## **PLANNING REFERENCE 23/04220/DIS**

Discharge of Condition 6 (Details of Services Internal & External) relating to Listed Building Consent 22/04272/LBC for the conversion of existing detached barn to self-contained ancillary accommodation and occasional holiday let use and refurbishment of distressed outbuilding affecting a Grade II Listed Building (re-submission)

LOCATION: Bronhaul, 6 High Street, Grinshill, Shrewsbury, Shropshire.

# Bronhaul Barn Window Design

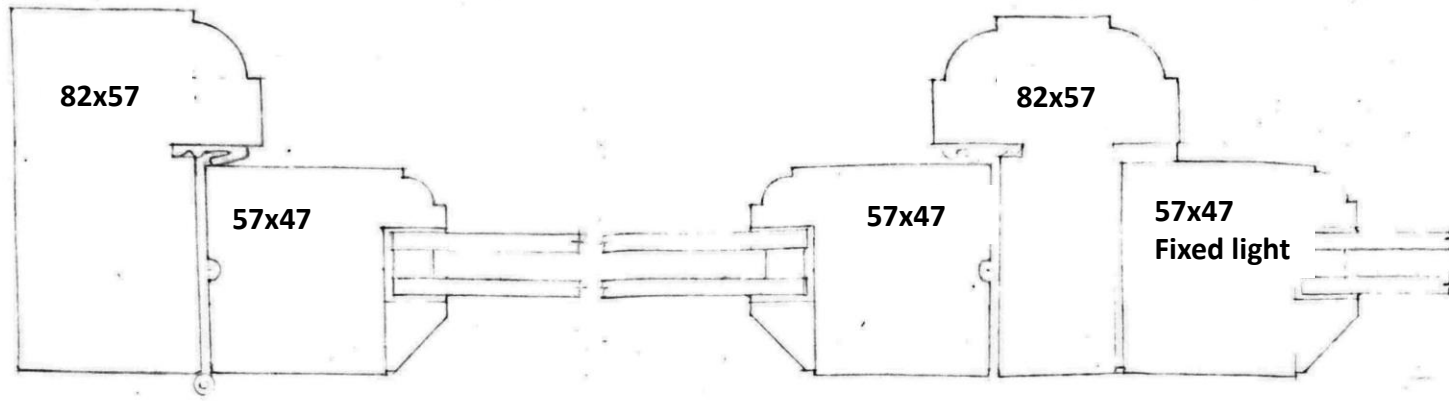
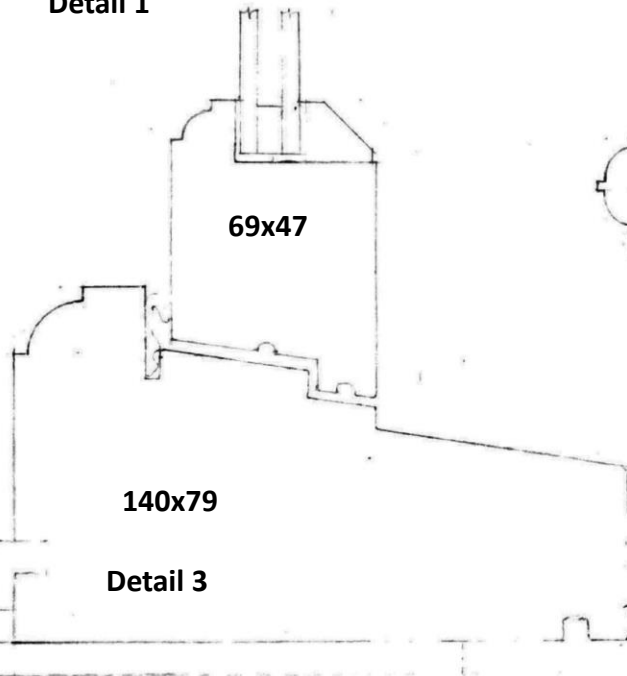
1. The applicant agrees to amend the window designs in terms of glazing bars and design, but no revised sections etc have been provided.

With regards to the window design then the proposal is that the current design is retained, with no cross bar. Unfortunately due to their age, wood worm infestation and general rot the current windows cannot not be repaired, however by retaining the existing design the original character/look of the barn will be retained.

I have provided a separate document which provides a cross section of the window design.

# Bronhaul Barn Door Design

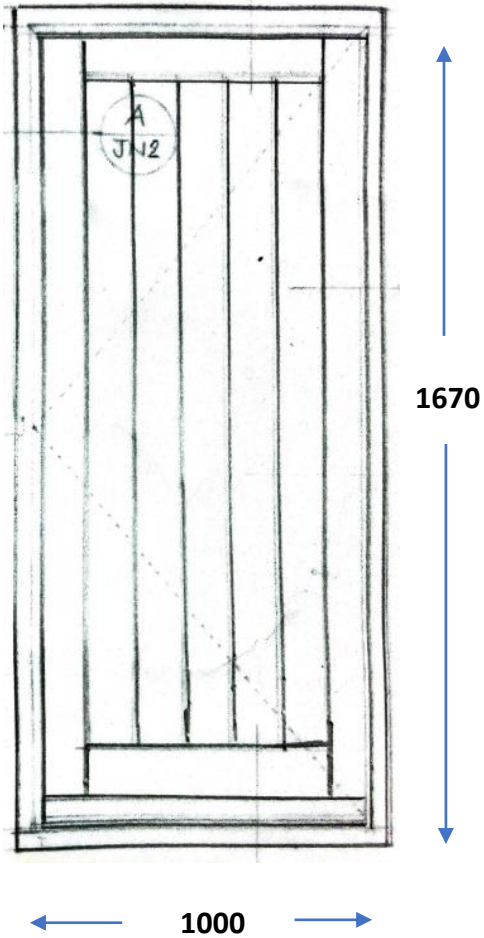
2. Door to kitchen - the case put forward is understood in terms of the privacy issues and it is not intended that the shutters are closed but pinned back. It is further understood that the doors may not have any historic value but the type of door opening was an openable solid timber door and the normal way to address these are to have a fully glazed door which in essence looks like it is open, hence the retention of an external door pinned back. If this needs to be addressed in terms of privacy then a more simple door style could be used, not one that appears whole domestic and alien to the overall appearance of this historic farm building/outbuilding. Whether the door is fully or partially glazed there is still the ability for overlooking into private areas in the courtyard. Unfortunately the condition cannot be discharged as there are no revised details to assess in any case.

Due to the front of the barn being visible from the road and neighbouring houses, as previously mentioned we are not keen to use a fully glazed door. This is further reinforced with the proposed plan to use the barn for occasionally holiday letting, with occupants not likely wanting a glass door opposite bedrooms and the kitchen.

In response to latest suggestion of plain door, we propose the following option:

We have provided a supplementary file which provides more details
